Re: Permit # SHL18-017
Project Name Lakeshores Group Community Dock
Project Address 5067 84th Ave SE (parcel # 407600-0080)
Reviewer Andrew Leon, Planner
Department Planning & Development

Below are our responses to the corrections in your letter dated March 21, 2022. Your original comments are in ***bold italics*** followed by our response in plain text.

SITE PLAN
SCALE 1" = 40'-0"

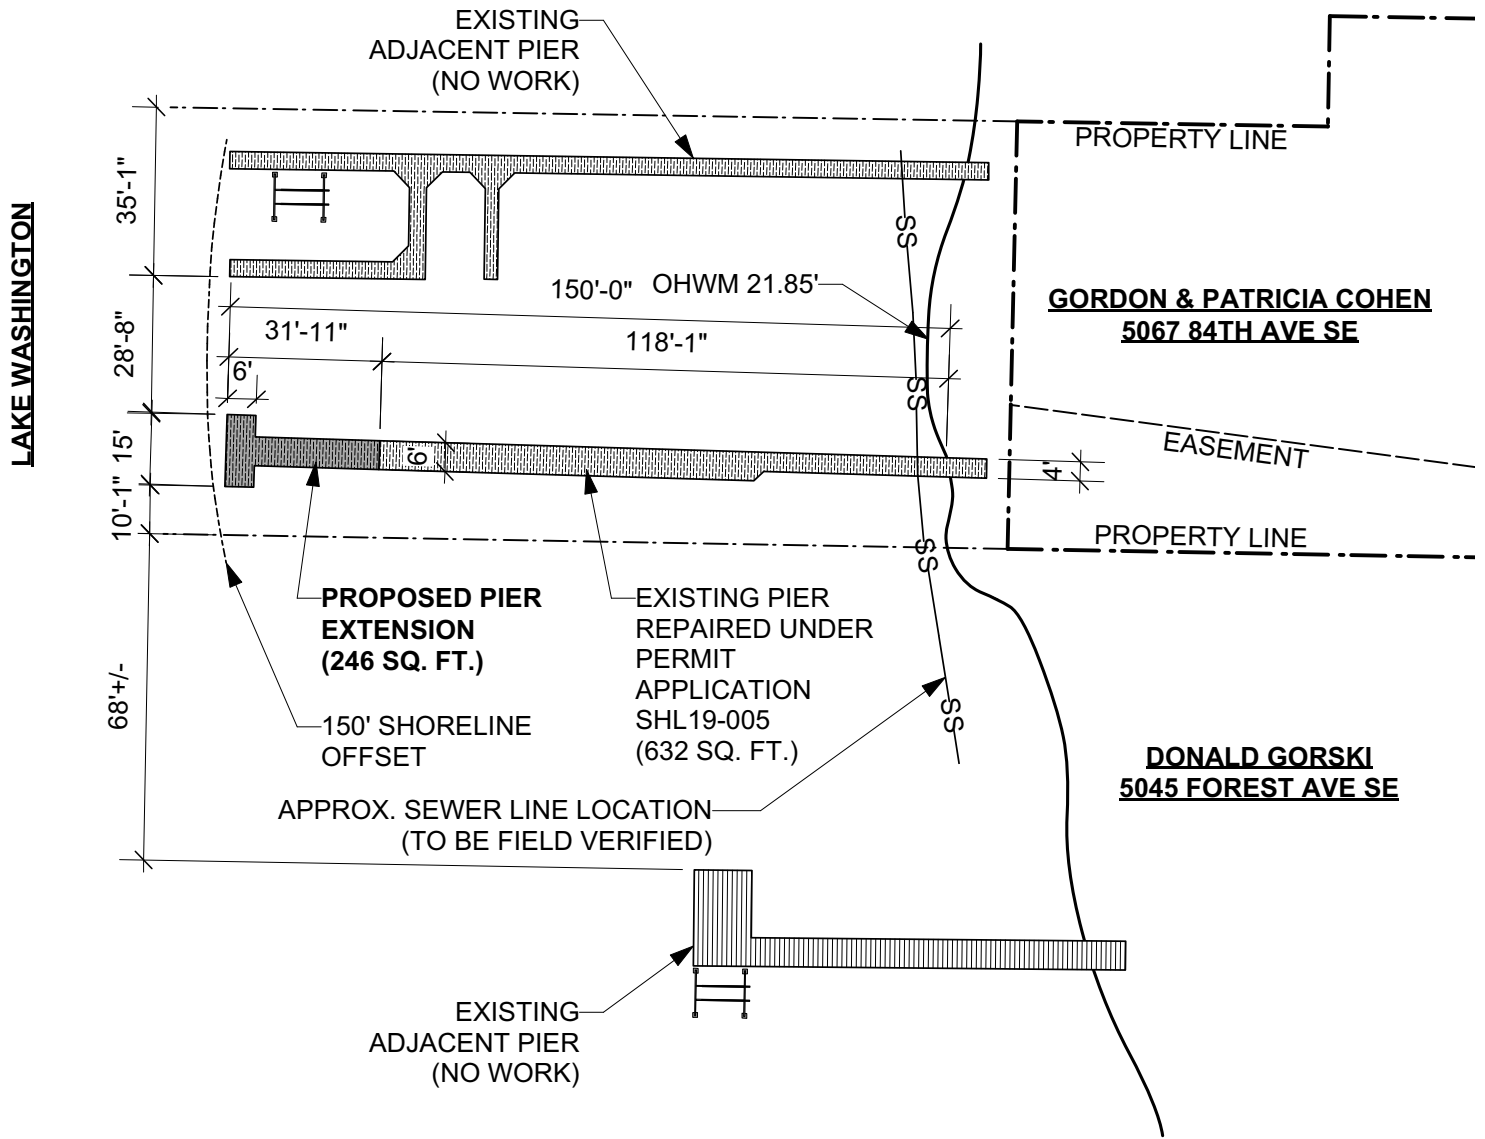
1. There is a storm system and a city sewer main with easements located on the subject lot at the approximate location of the waterfront access easement. The sewer and storm lines, as well as the easements that contains them, needs to be shown on the site plans and the shoreline planting plan (Sheets 2, 3, and 7 of the plan set). No trees or larger bushes should be planted within the sewer or storm system easements.

1. Please show the sewer lake line and its associated easement on the site plans, pile layout sheet, and shoreline planting plant (Sheets 2, 3, 5, and 7 of the plan set). New piles cannot be located within the easement.

The sewer and storm system easements have been added to sheets 2, 3, and 7. The proposed plantings in the easements have been removed from the plans.

The sewer lake line and easement has been added to sheets 2, 3, 5, and 7 on the plans. New piles will be located at the western side of the pier and no new piles will be located near or in the sewer lake line easement.
